CITY OF ALBUQUERQUE

September 28, 2010

Re: Jerry Cline Park, 7205 Constitution, Grading and Drainage Plan
Engineer's Stamp dated 9-12-11 (J19/D26)

CITY OF ALBUQUERQUE PARKS & RECREATION DEPARTMENT										
TITLE: CITY OF ALBUQUERQUE JERRY CLINE PARK GRADING PLAN										
Design Review Committee			City Engineer Approval			Last Design Update	Mo./Day/Yr.		Mo./Day/Yr.	
City Project No.		Zone Map No.								
677402		J-19

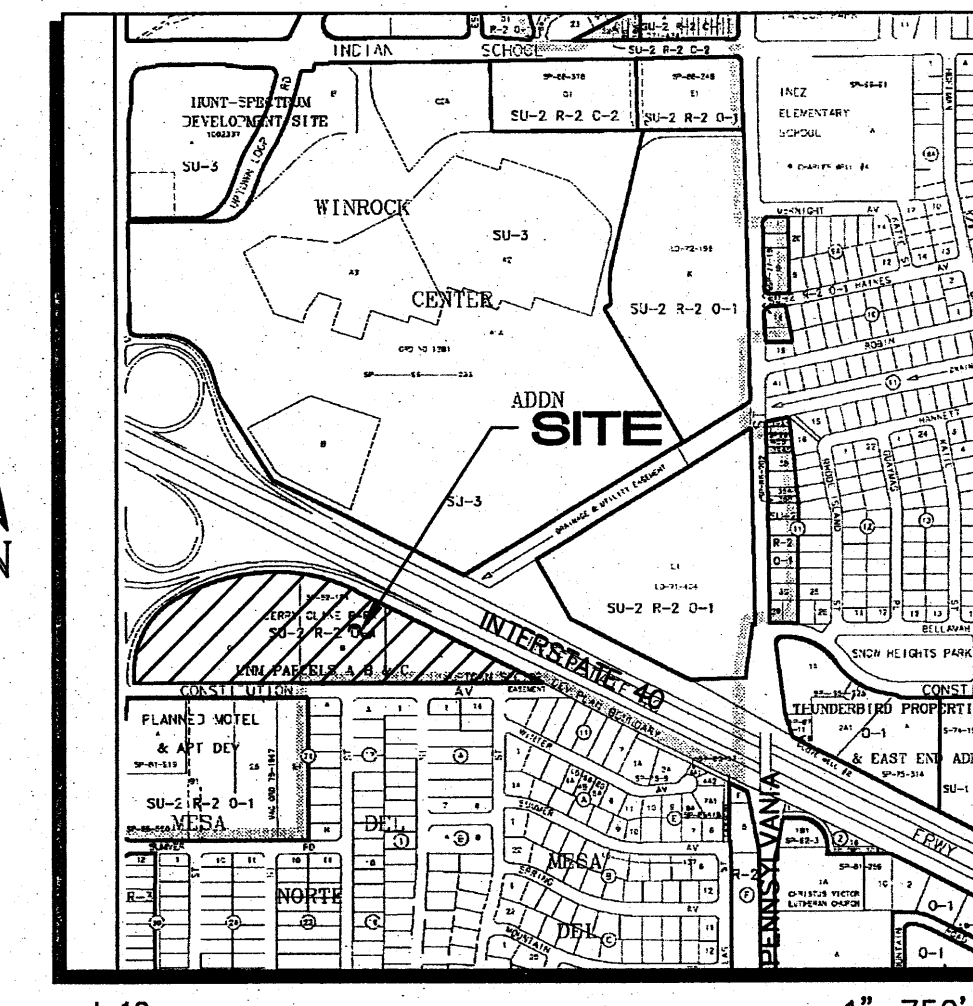
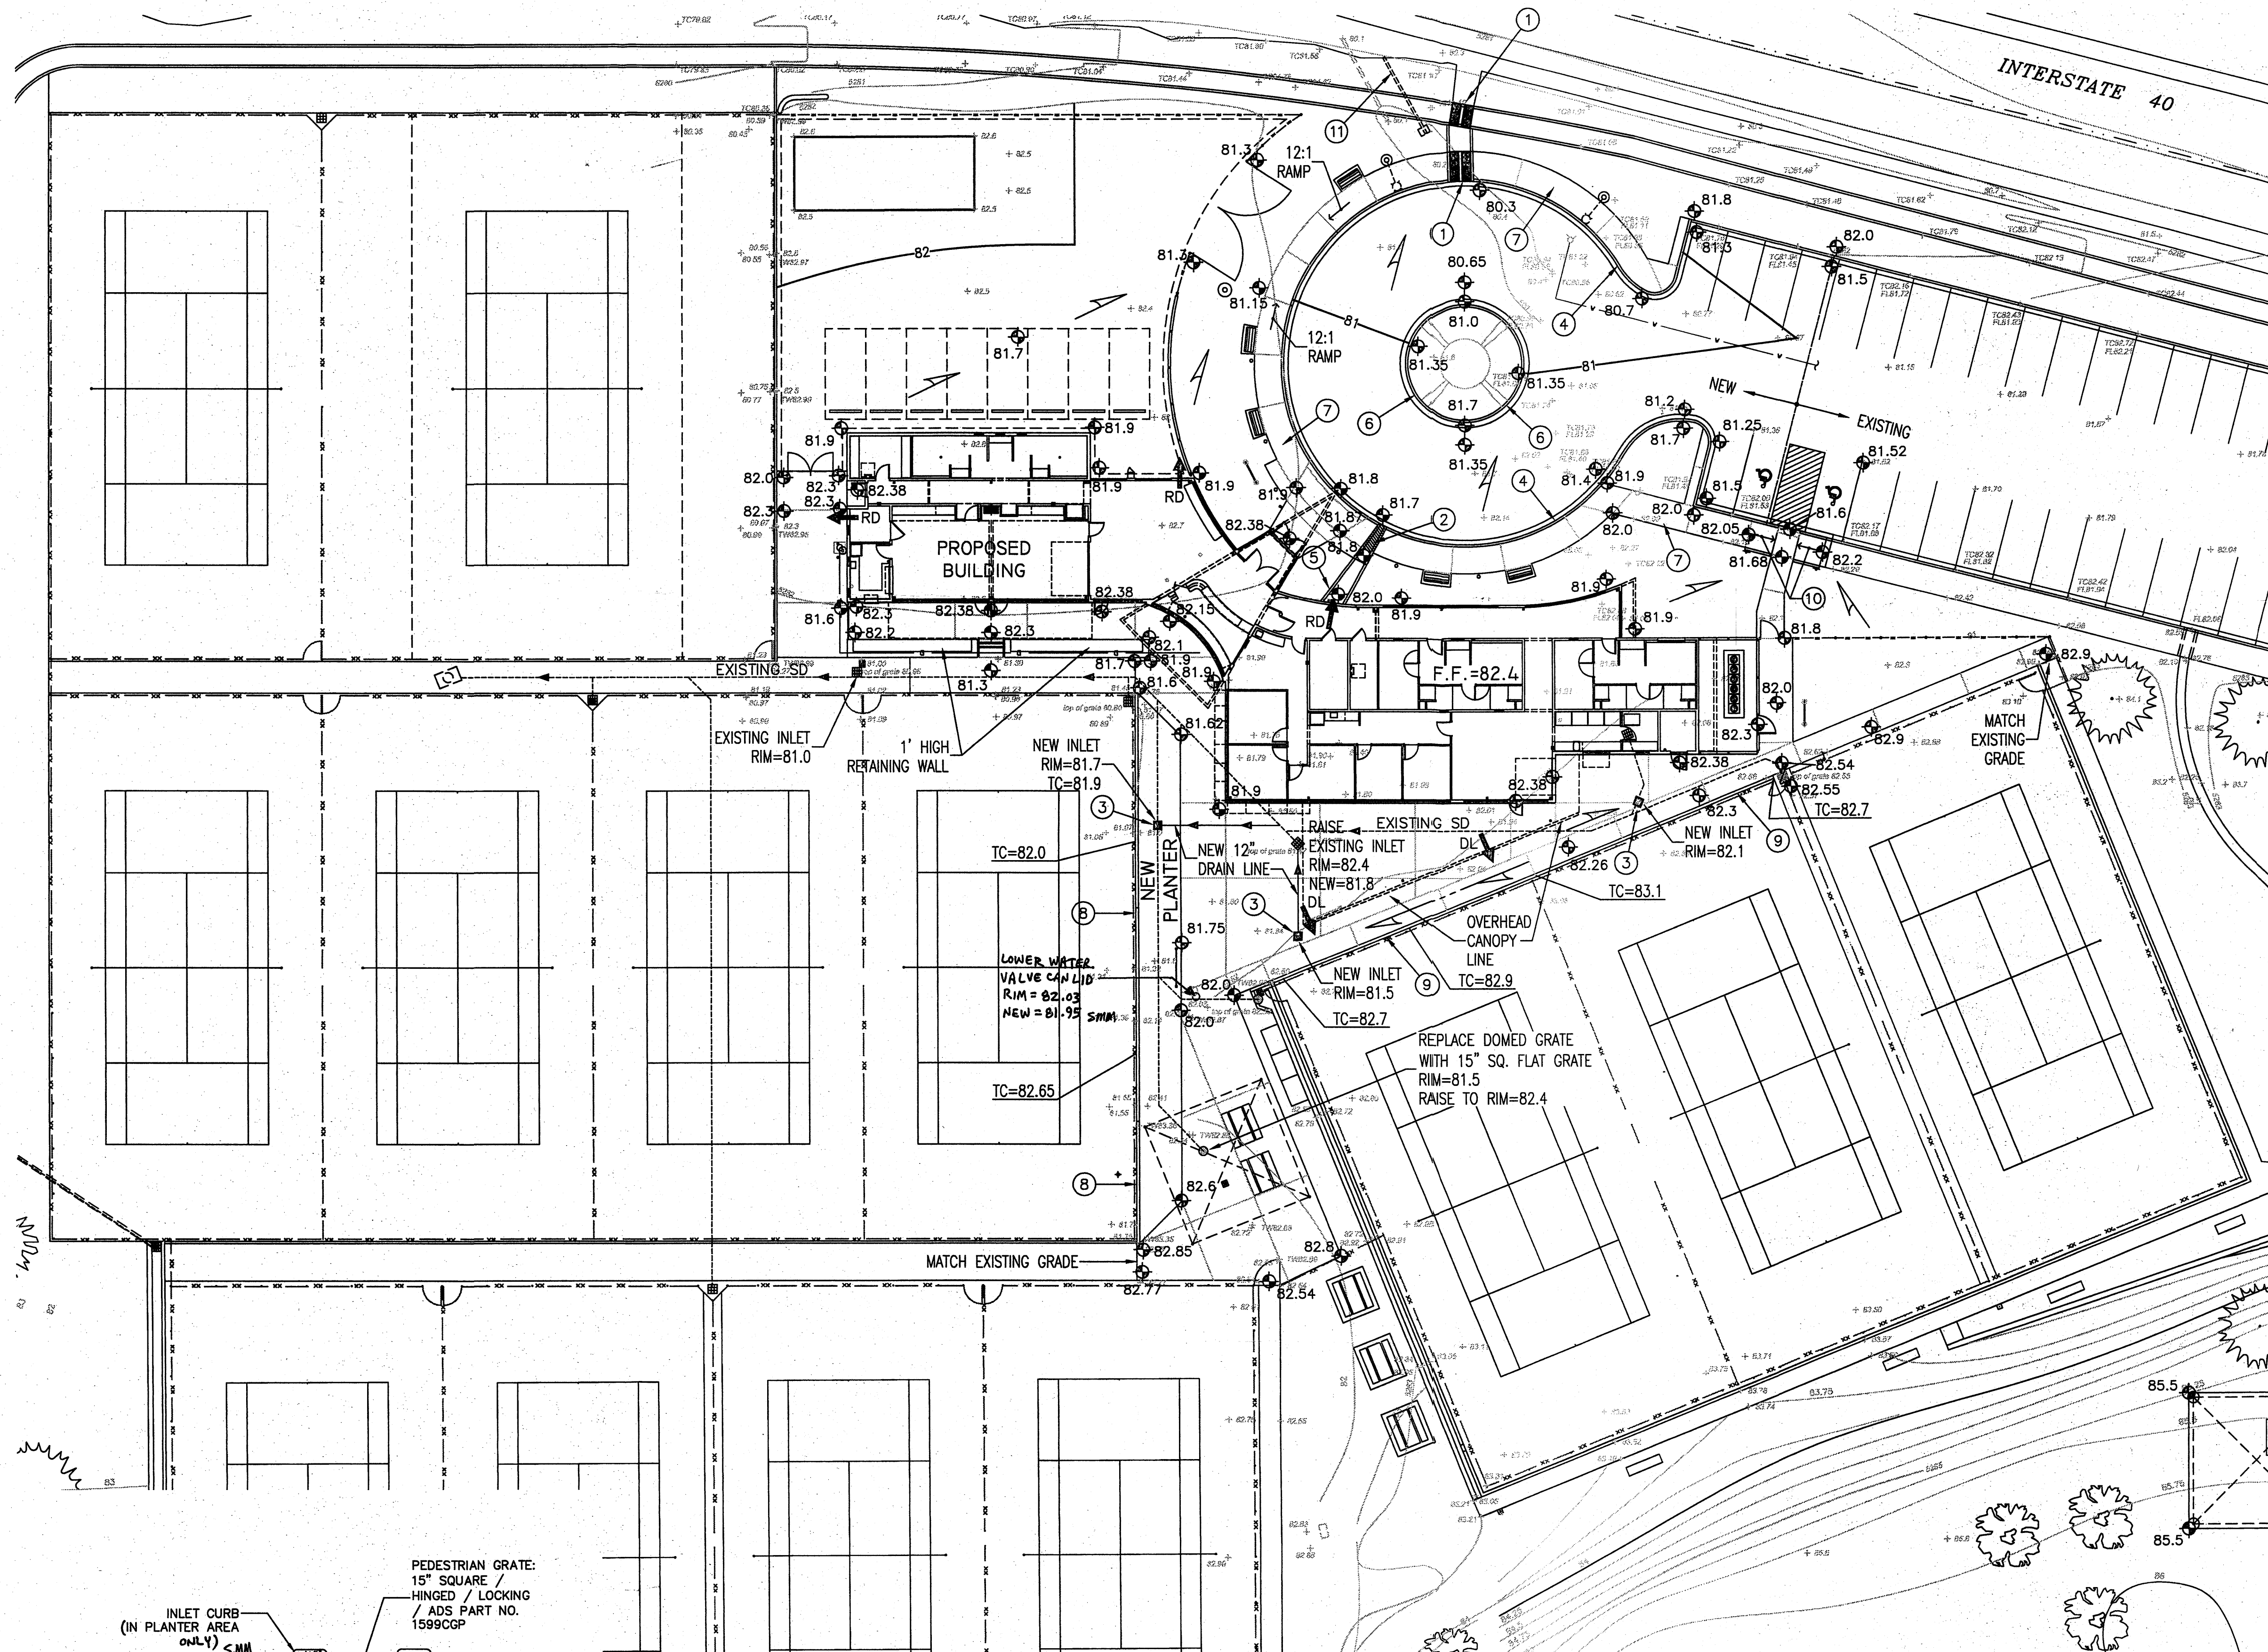
- BM information provided should be based on NAVD 88. Please make sure the existing and proposed elevations does reflect the NAVD 88.
- Can not read the existing spot elevations and contours.

- Show the property line.
- It appears that the proposed 24" sidewalk culvert will be draining to an existing swale to the north. Is there any erosion protection proposed from the end of the sidewalk culvert to the existing swale. Provide details.

- Provide capacity calculations for all the proposed inlets, sidewalk culverts, and other drainage structures. Provide details for the tapered 24" side walk culvert and the tapered u-shaped concrete swale to sidewalk culvert.

- Will existing storm drain structures that fall under the building be removed and rerouted?
- Provide finished floor elevations for all the building.
